Lime Down

Solar Park

Statement of Common Ground with Environment Agency (Tracked)

Planning Inspectorate Reference: EN010168

Title:
Figure 11.3 Rev 4: Lime Down C1 Fluvial
and Surface Water Flood Risk Map

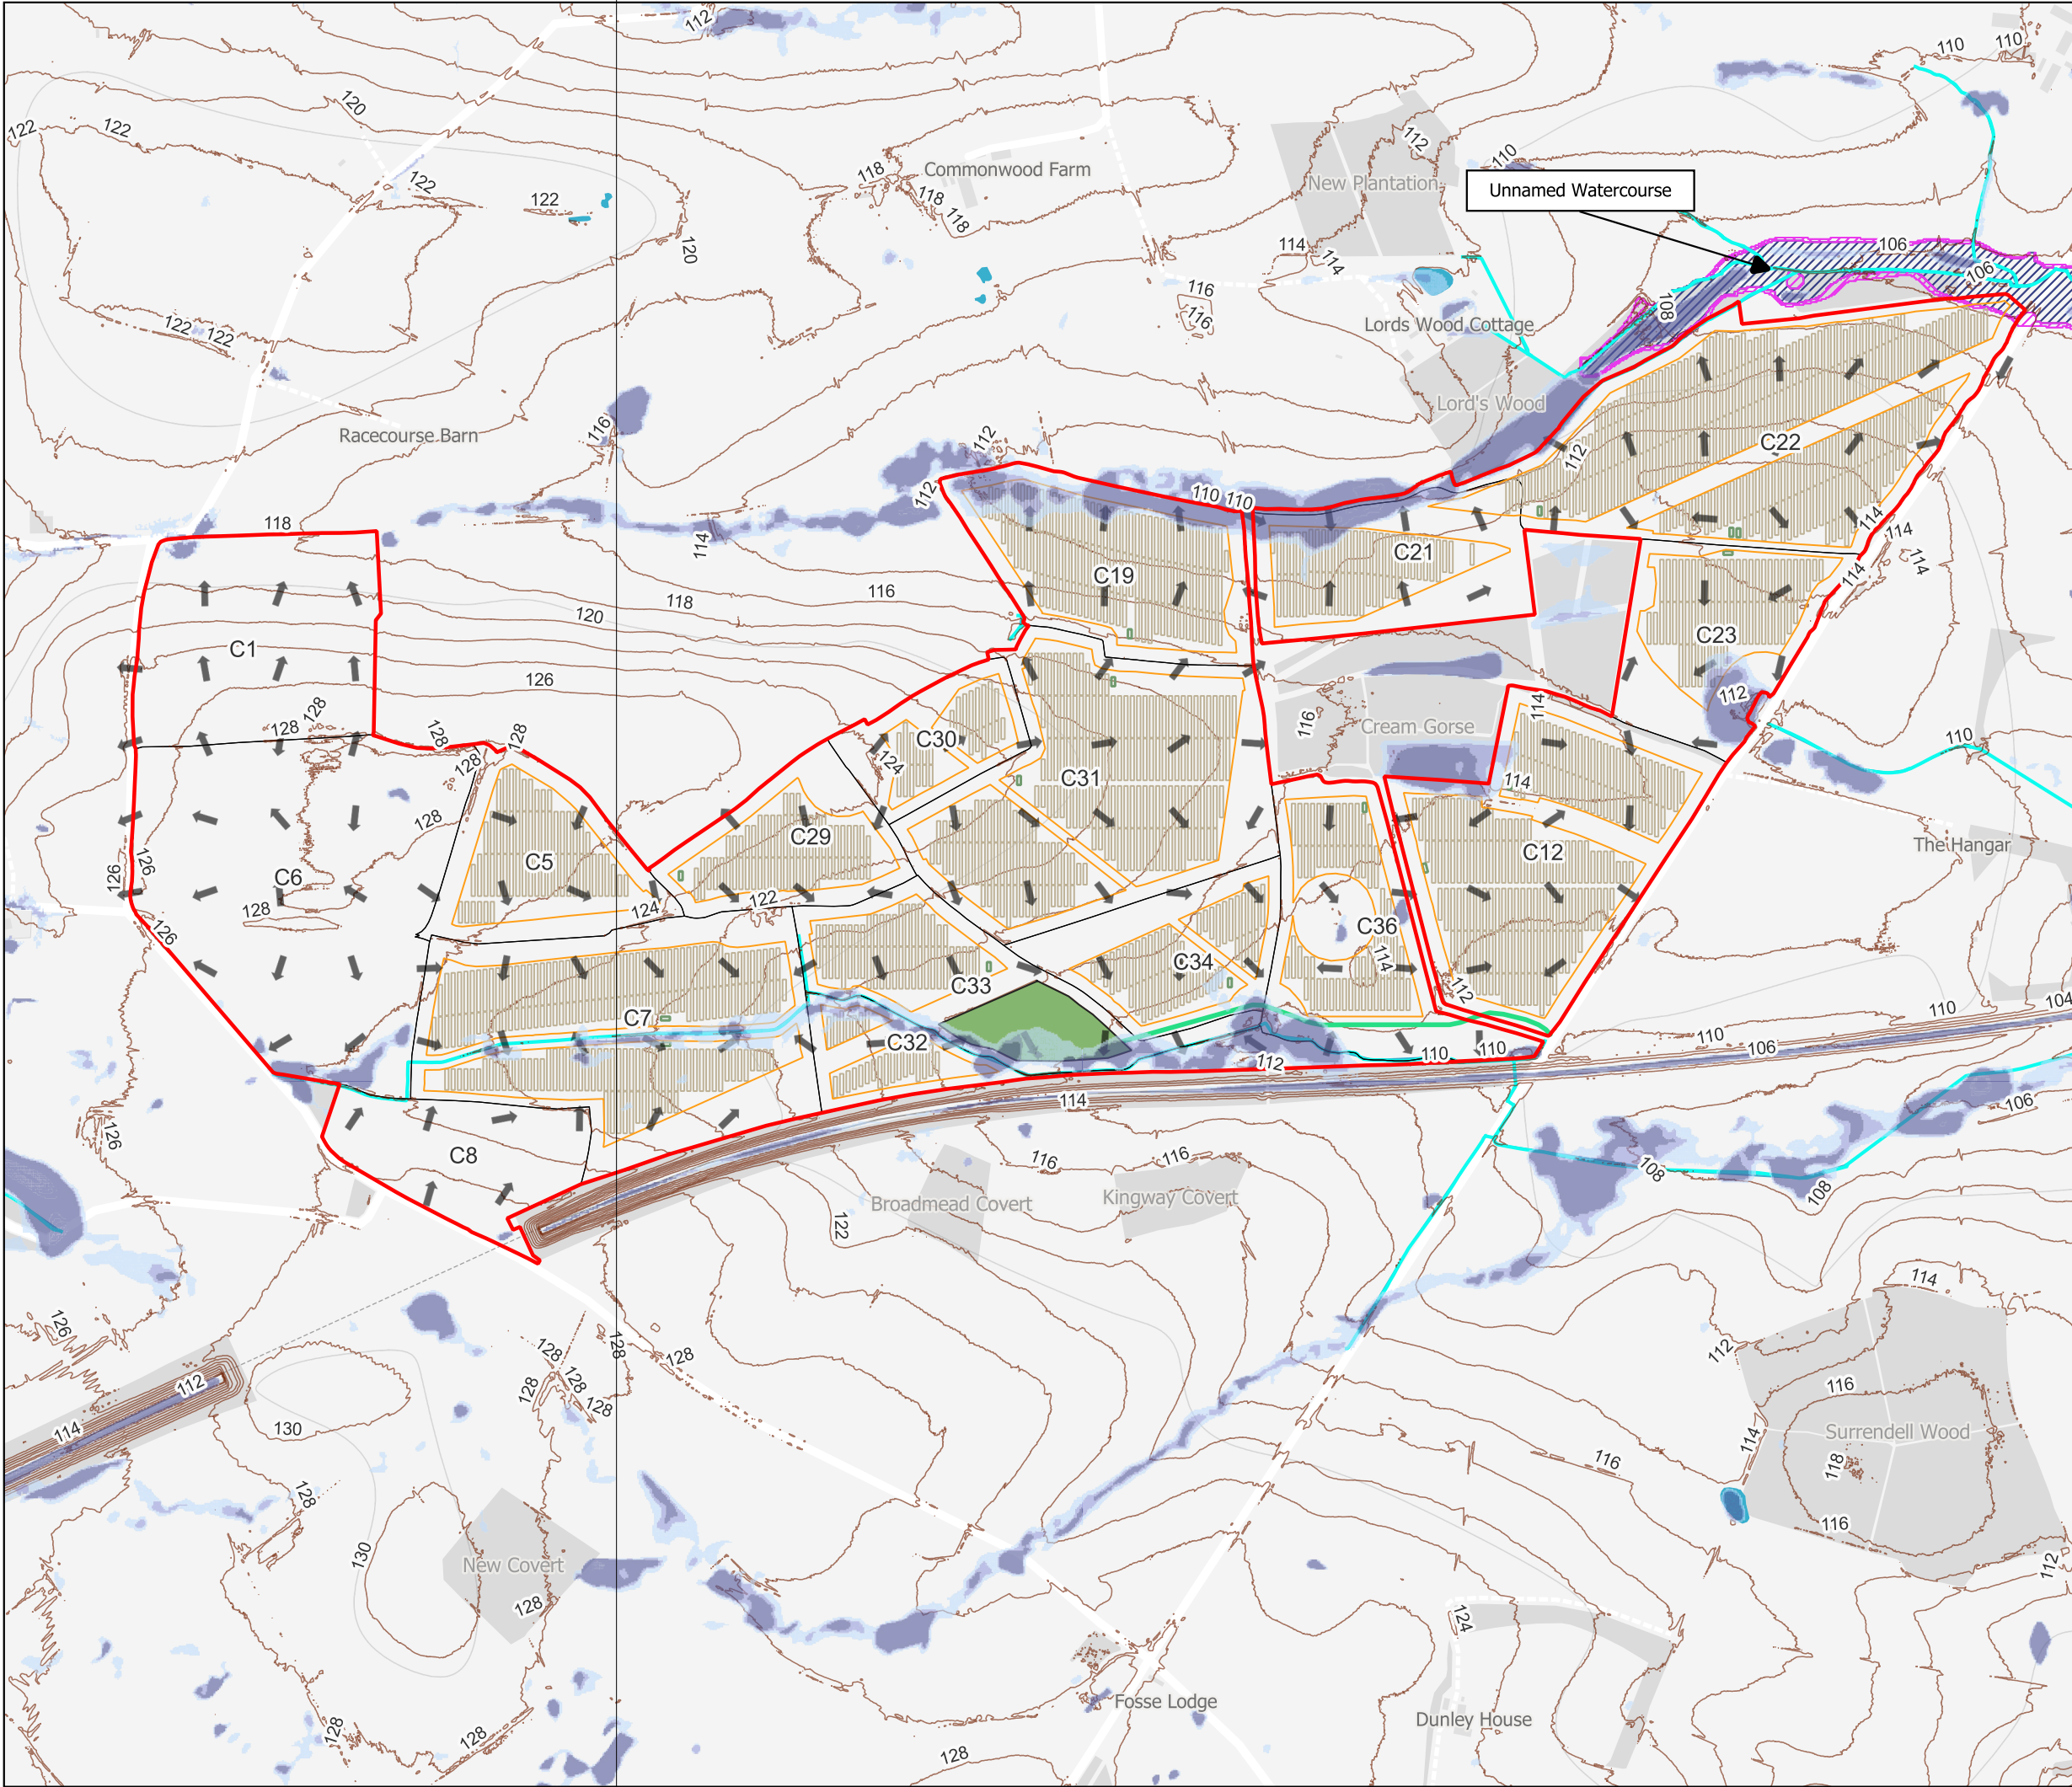
3.3.10	Floodplain Interaction and Displacement	The Environment Agency has requested clear reporting and evidence of floodplain displacement assessment to demonstrate flood risk neutrality.	The Applicant notes that this matter has been addressed in the revised floodplain displacement assessments submitted at Deadline 1. and further reported in the Applicant's response to	Under Discussion

Reference	Sub-topic	EA Position	Applicants Position	Status
		If it is not possible to place the substation within Lime Down C1 outside of the mapped flood flow routes, further assessment will be undertaken at detailed design to determine if the placement of the substation within Lime Down C1 would increase flood risk elsewhere. If there is an increase to flood risk elsewhere, floodplain compensation will be provided, in consultation with the Environment Agency, to ensure that there is no increase in flood risk. Engagement with the EA will occur throughout the detailed design stage on the need, method of calculating volumes, modelling and design of any floodplain compensation that may be required. <u>We would need to secure this through a requirement within the Development Consent Order. We would request the following wording to secure this:</u> <u>Flood Mitigation Requirement</u> <u><i>No development shall take place within Lime Down C1 until the location of the</i></u>	EA-049 in Applicant's Response to Comments Received at Deadline 2 [REP3-129]. The separate point raised by the Environment Agency in relation to the potential placement of the Lime Down C1 substation within mapped flood flow routes is addressed below. Interaction with the floodplain has been avoided where practicable through layout design. Where limited interaction remains, the Applicant has assessed displacement from the proposed solar panel supports using a deliberately conservative methodology. The assessment assumes displacement is redistributed only across the modelled flood extent within the relevant Lime Down site boundary, rather than across the wider hydraulically connected floodplain. This is precautionary, as in practice any displaced floodwater would be distributed over a substantially larger floodplain area. For Lime Down D, the assessment identifies a displaced volume of 11.59m³, redistributed across an on-

Reference	Sub-topic	EA Position	Applicants Position	Status
		<u>substation has been confirmed, an assessment of flood risk has been undertaken and a mitigation plan have been submitted to, and approved in writing by, the Local Planning Authority, in consultation with the Environment Agency, and these works shall be carried out as approved.</u> - <u>Note:</u> <u>Should the assessment show increased flood risk, the mitigation plan should include a Floodplain Compensation Scheme. Any proposed compensation scheme must demonstrate:</u> <u>a) no net loss of floodplain storage within the design flood event;</u> <u>b) compensation provided on a level-for-level and volume-for-volume basis where appropriate;</u> <u>c) no increase in flood risk elsewhere;</u>	site modelled flood extent of 222,530m². This results in a theoretical increase in flood level of approximately 0.000052m. For Lime Down E2, the assessment identifies a displaced volume of 2.09m³, redistributed across an on-site flood extent of 50,735m². This results in a theoretical increase in flood level of approximately 0.000041m. In both cases, the calculated increase is de minimis, several orders of magnitude below the precision at which flood levels can be meaningfully defined, and would not result in any measurable change to flood levels, flood extents, flow routes or flood risk to third parties. The revised assessments also include figures showing the flood extent and displacement calculation areas for Lime Down D and Lime Down E2. The Applicant therefore considers that the assessment demonstrates flood risk neutrality and that compensatory flood storage is not necessary or proportionate. The Environment Agency has confirmed that the

Reference	Sub-topic	EA Position	Applicants Position	Status
		<u>d) implementation of compensatory storage prior to the associated floodplain loss; and</u> <u>e) appropriate maintenance of the compensation scheme is in place during the operation phase.</u>	Applicant has provided sufficient evidence to demonstrate that loss of floodplain storage would be negligible in the context of Gauze Brook and Gabriel's Well / Rodbourne Brook. In relation to Lime Down C1, the Applicant will continue to engage with the Environment Agency through detailed design on the siting of the substation, the need for any further flood risk assessment, and the method and design of any floodplain compensation or other mitigation that may be required. Any residual matter relating to the delineation or application of Flood Zone 3b is addressed separately under row 3.3.17. For Lime Down C1, the Applicant confirms that the 132 kV substation location remains subject to detailed design. The detailed design will first seek to locate the substation outside the mapped flood flow routes identified within Lime Down C1. If this is not practicable, a site-specific assessment will be undertaken at detailed design
